Application No: K/25/21/HH  
Site Address: Spinnakers 59 Coastal Road Kingston BN16 1SW  
Description of works: Erection of two storey front extension, single storey side and rear extension with new rear balcony and external remodelling

Thank you for your internet representation made on 22nd June 2021 which has been recorded as no objection with the comments as follows:

OWPC37634

Drawing Name  
**First Floor Plan -  
Proposed**

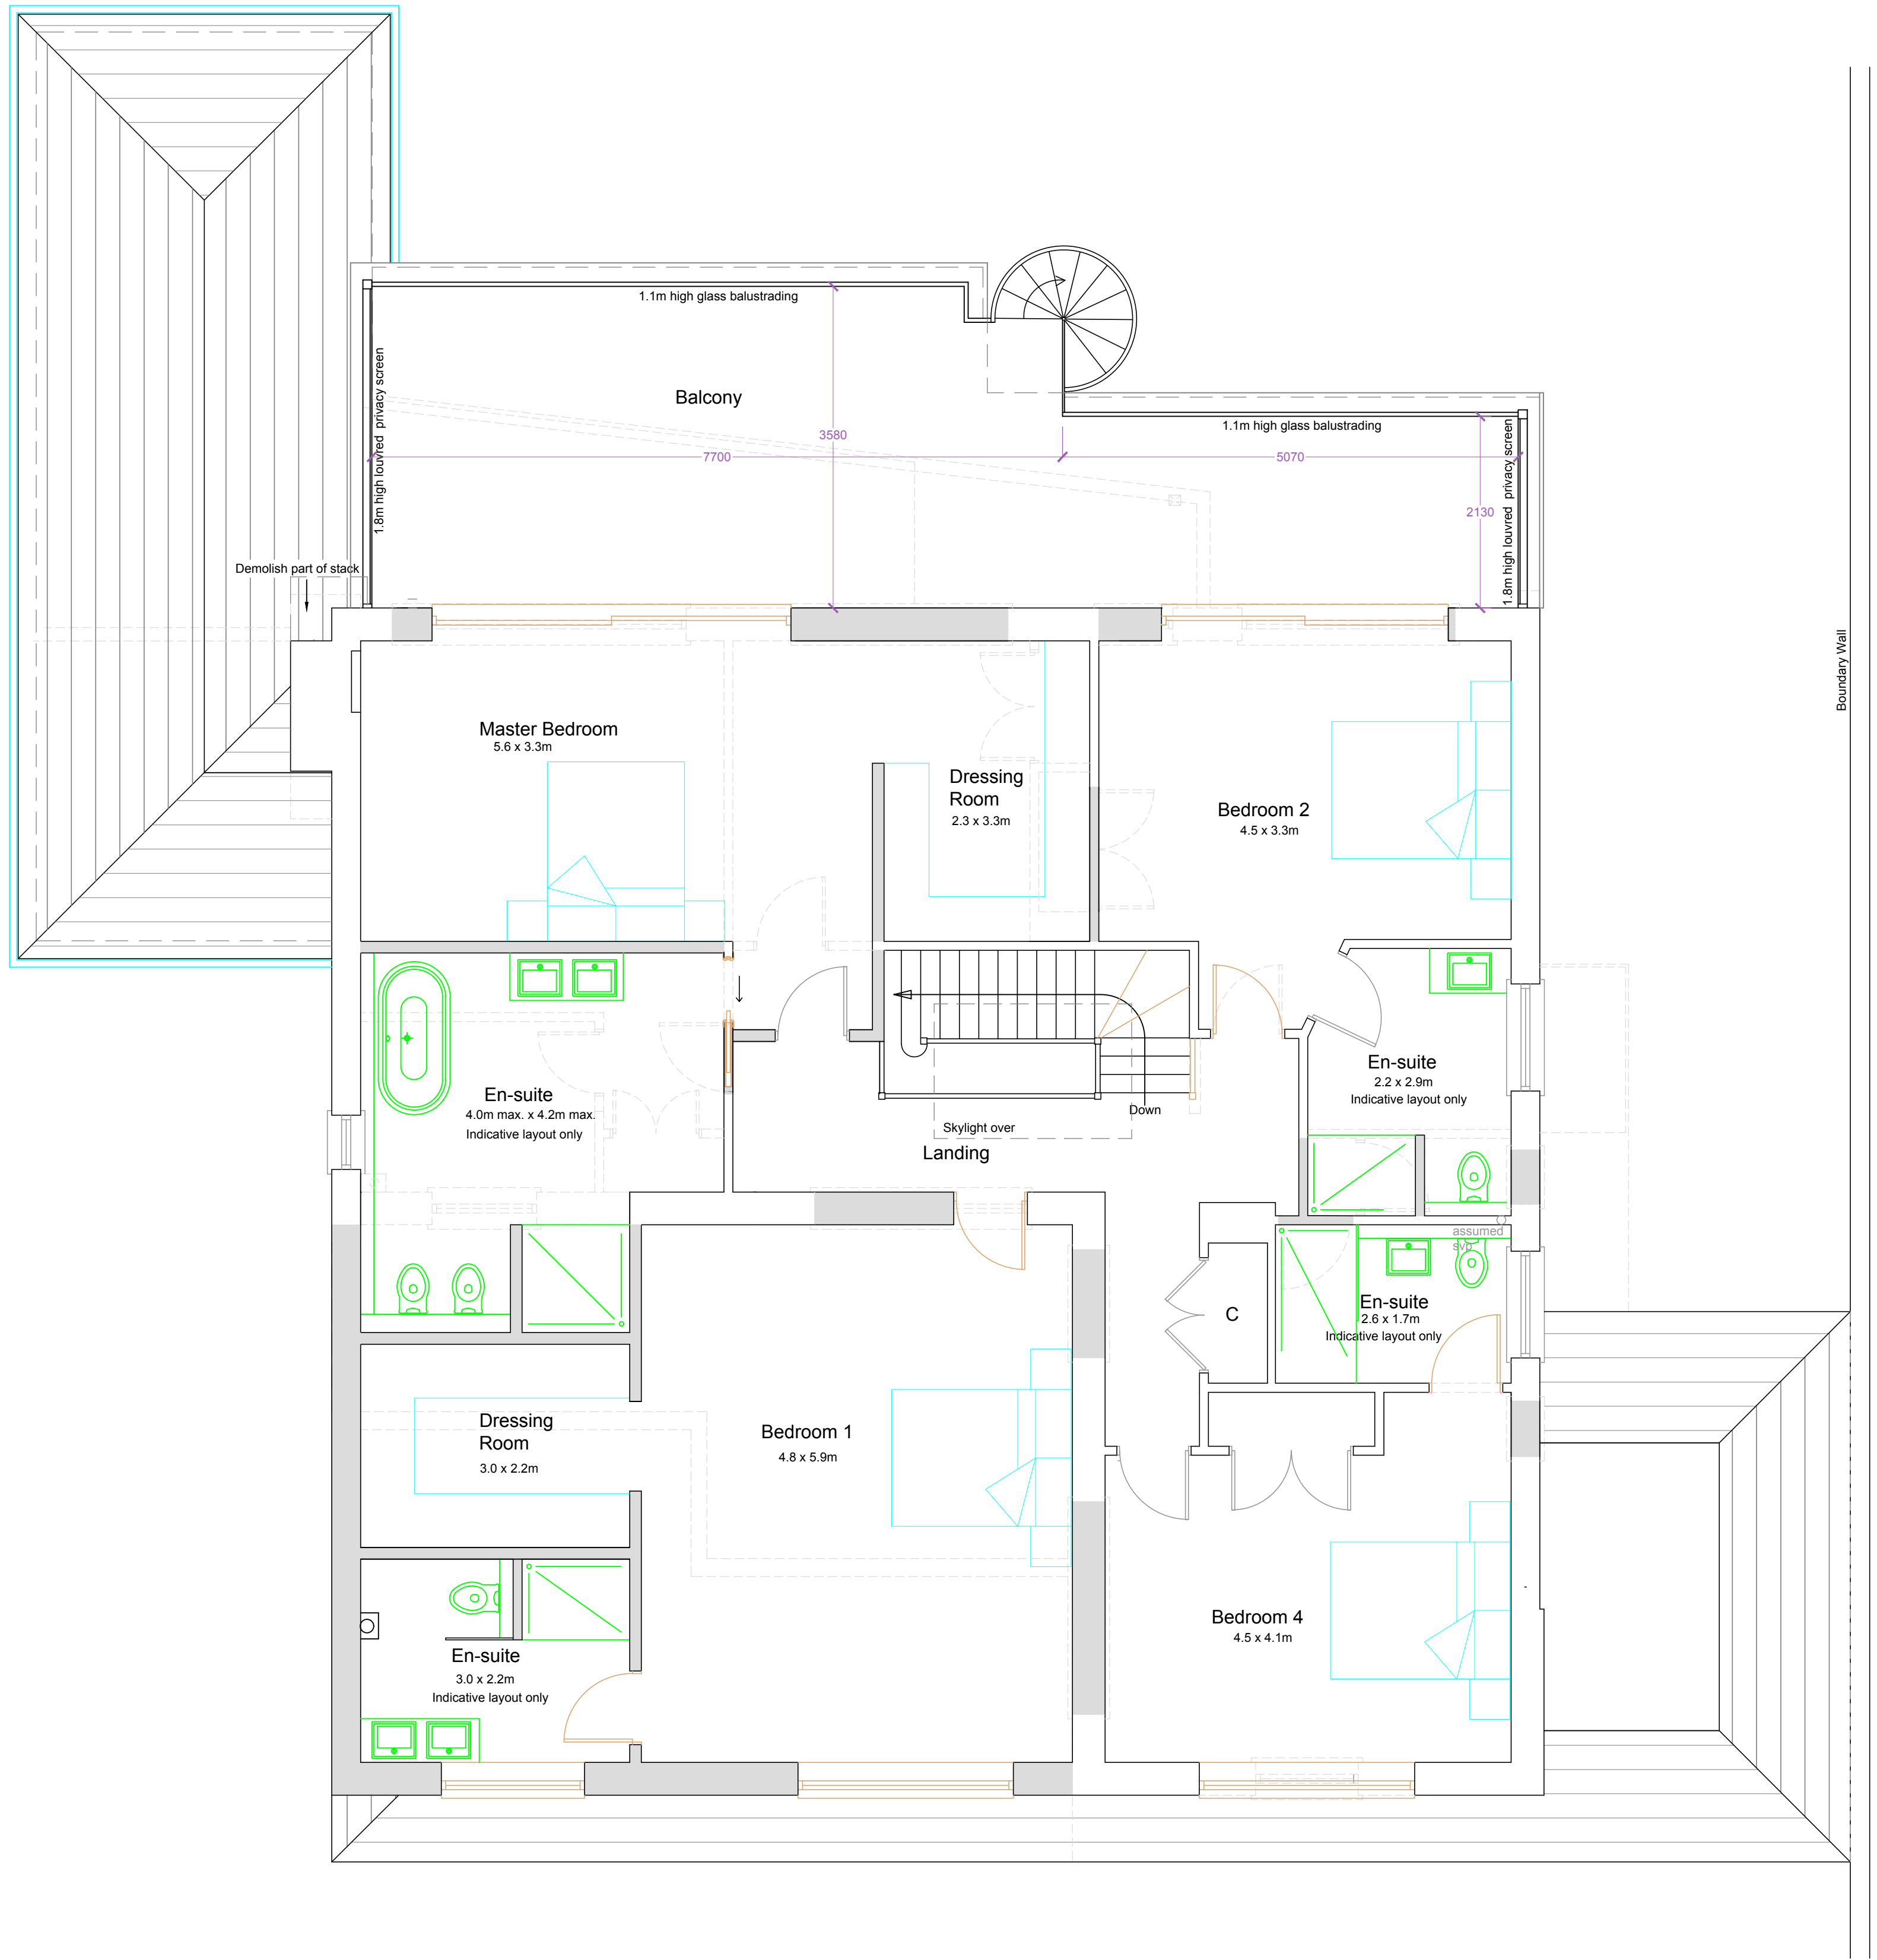
No objection providing the case officer is satisfied there is no undue overlooking of neighbouring properties from the new balcony and external staircase, particularly to the west where the proposed privacy screen is not as deep as the privacy screen to the east and so does not extend to the full depth of the entire balcony and staircase.
